Maxwell Project – Response to DPIE Questions (Received 24 July 2020)

ID	DPIE Question	Malabar Response
	Groundwater	
1	Section 6.2 of the Groundwater Assessment (GA) states: “The location of drawdown associated with the reduction in upward seepage along Saddlers Creek and Saltwater Creek is shown on Figure 85.” This is not shown on Figure 85.	This text should reference Figure 73 (Maximum drawdown due to Project, Layer 1).
2	Section 6.3 of the GA states: “Figure 85 shows that there is no change in baseflow along Saddlers Creek and Saltwater Creek.” Figure 85 does not provide any data with respect to Saltwater Creek.	<p>There would be no change in baseflow along Saltwater Creek (Section 6.3 of the Groundwater Assessment).</p> <p>Accordingly, the Saltwater Creek data series is the same as the Saddlers Creek data series shown on Figure 85 (i.e. zero increase in river leakage).</p>
3	Section 6.3 of the GA indicates that the Project is unlikely to significantly impact baseflows along Saddlers Creek, as the stream exhibits losing conditions in this location. However, both the EIS and the BDAR indicate that Swamp Oak along Saddlers Creek in the vicinity of the mining area is dependent on

**Figure 4.1**

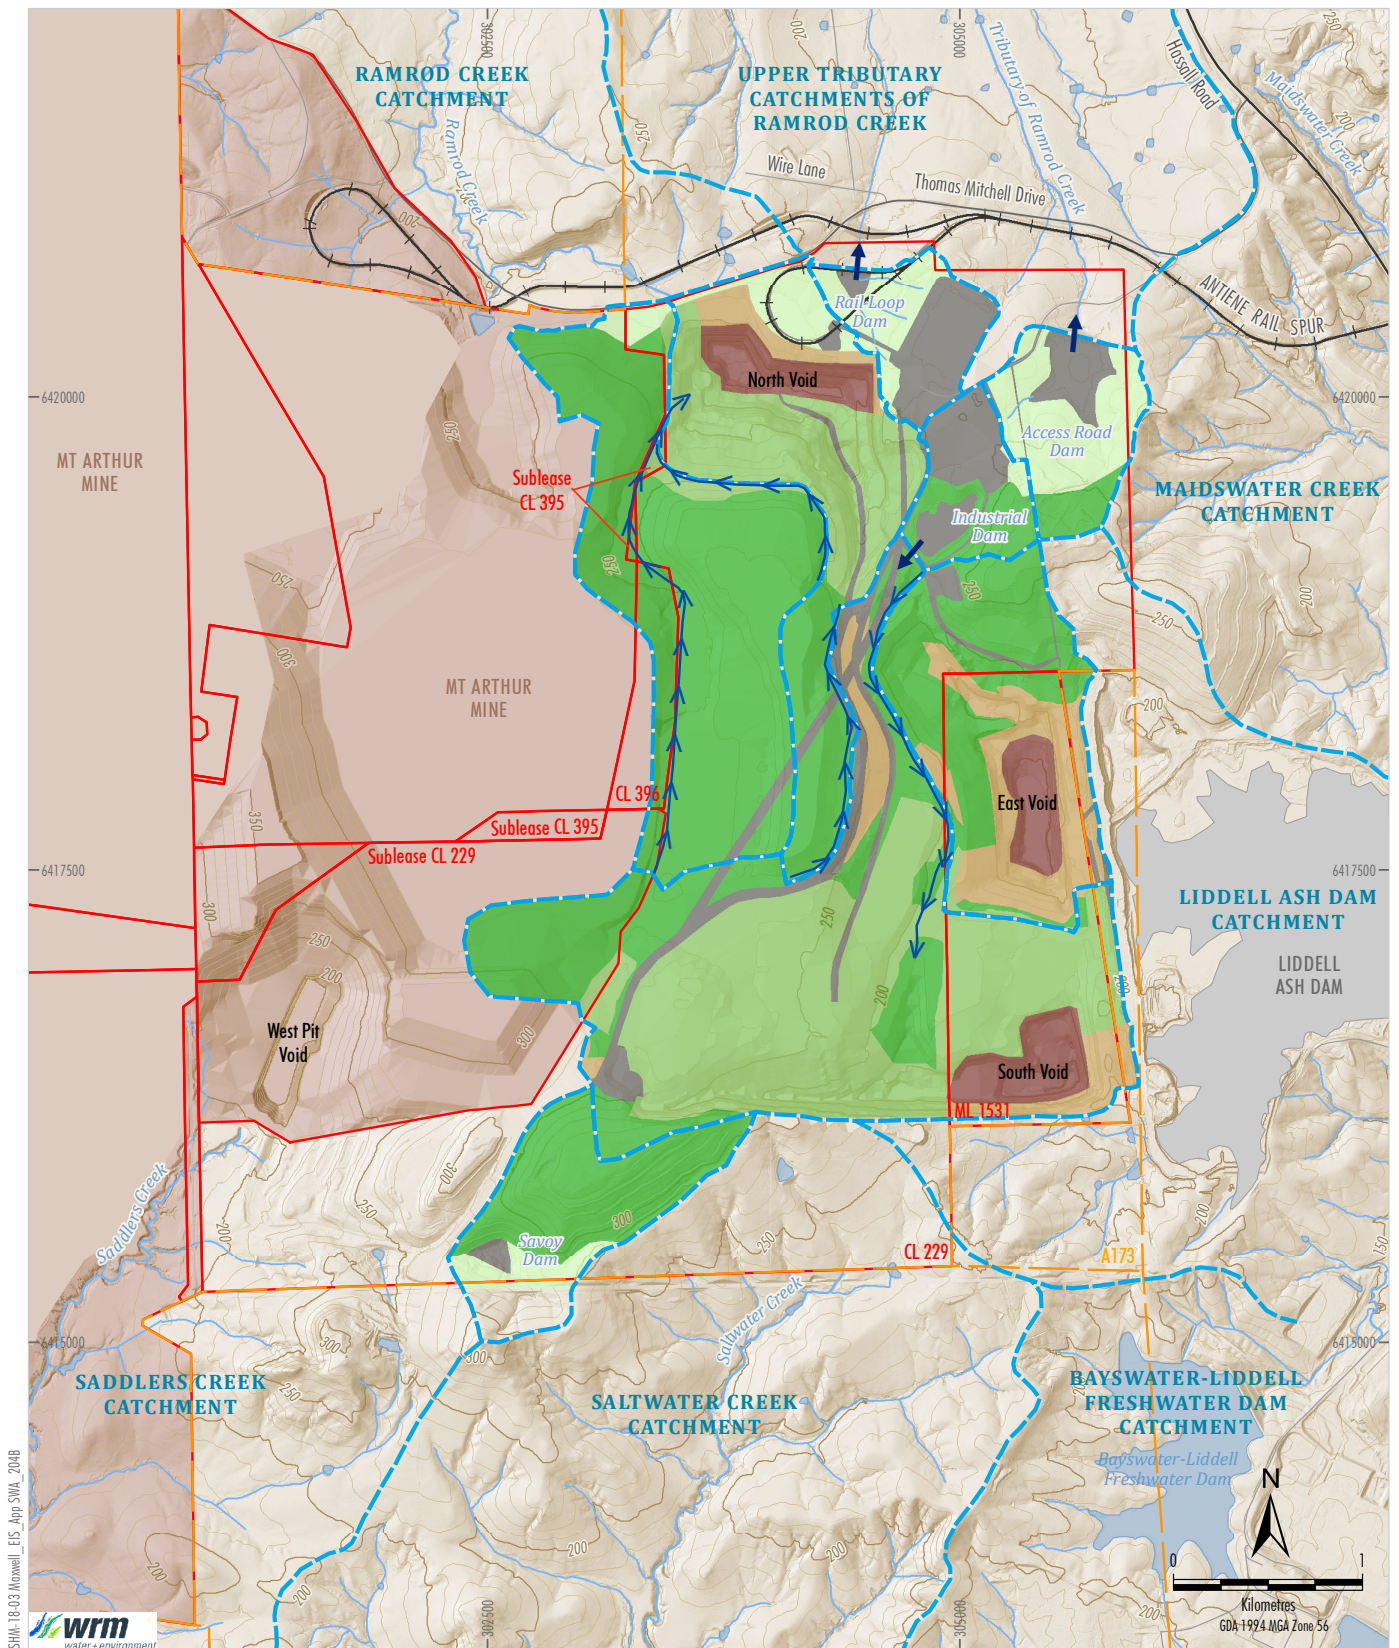
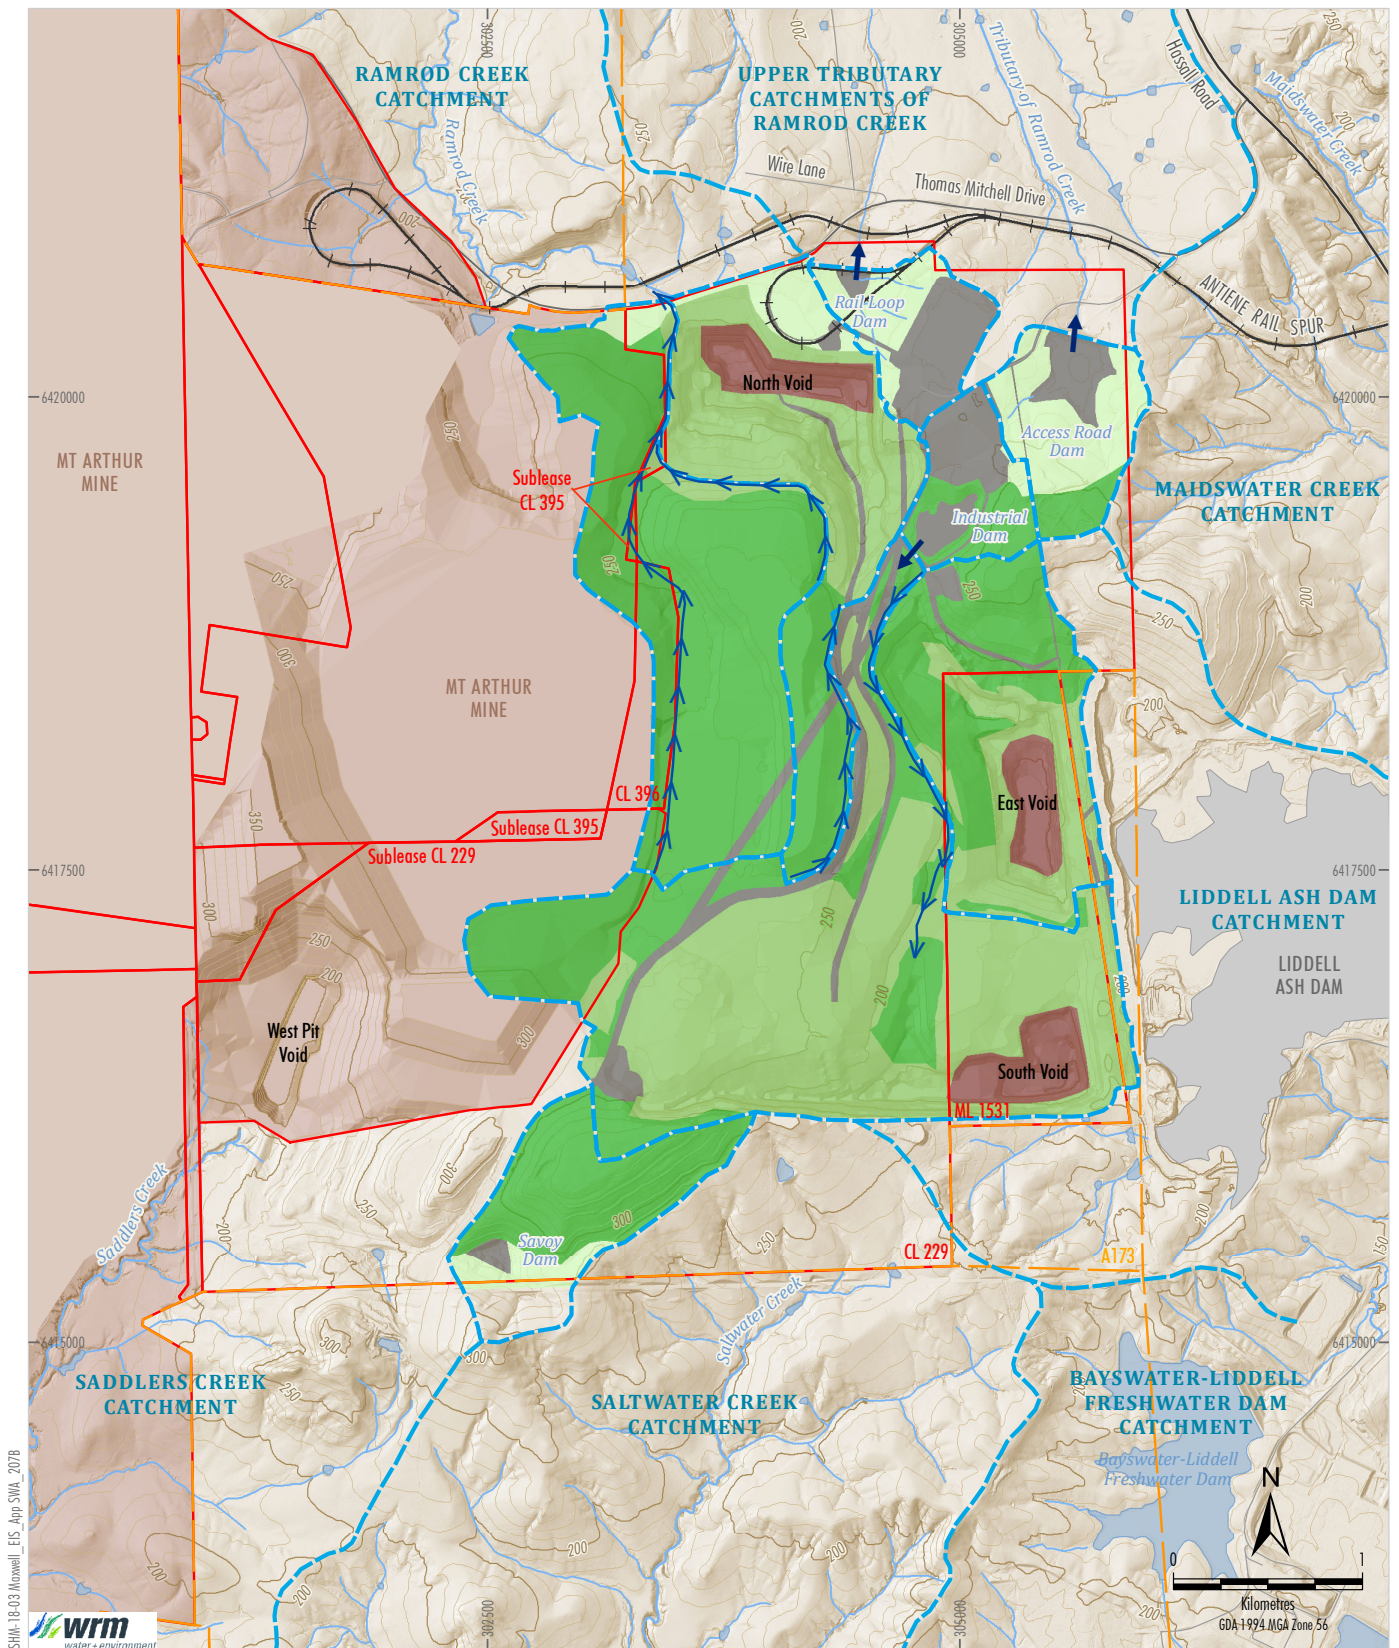
10	It is unclear how the transport and services corridor integrates with Figures 4.1 to 4.3 of the SWA.	<p>The water from the transport and services corridor would be managed by the dirty water management system and would therefore not be captured in the mine water management system. Accordingly, it is not shown on Figures 4.1 to 4.3 of the Surface Water Assessment.</p> <p>This is consistent with the management of the transport and services corridor described in Sections 4.3.4 and 9.1.5 of the Surface Water Assessment (refer relevant quotes below).</p> <p>Section 4.3.4 of the Surface Water Assessment states:</p> <p><i>Surface runoff from disturbance areas that drain off-site would be managed by the dirty water management system to reduce sediment loads. As the majority of the catchments at Maxwell Infrastructure and mine entry area drain internally to site storages, this would mainly comprise the transport and services corridor and upcast ventilation shaft site (including shafts, associated fans and ancillary infrastructure).</i></p> <p>Section 9.1.5 of the Surface Water Assessment states:</p> <p><i>An erosion and sediment control plan would be developed to manage runoff during the construction phase and to manage runoff from the disturbed areas peripheral to the mine entry area (i.e. transport and services corridor).</i></p>

ID	DPIE Question	Malabar Response
11	Does Malabar have/need an agreement with HVEC to permit the minor intrusion of the proposed diversion drain around the western emplacement area into CL 396 (as shown in Figure 4.3 of the SWA)?	<p>The proposed diversion drain is assumed to be established in Stage 3 of the site water balance model, after the final landform in this area has had time to establish (nominally Year 8 of the Project).</p> <p>As discussed in Section 2.3.3 of the EIS, the approved Mining Operations Plans for Mt Arthur Mine and the Maxwell Infrastructure both show potential integration between the final landforms. Malabar would continue consultation with BHP regarding potential interactions between the Maxwell Infrastructure and Mt Arthur Mine final landforms.</p> <p>In the event an agreement couldn't be reached, the proposed diversion could be amended slightly to remain within Coal Lease 229.</p>
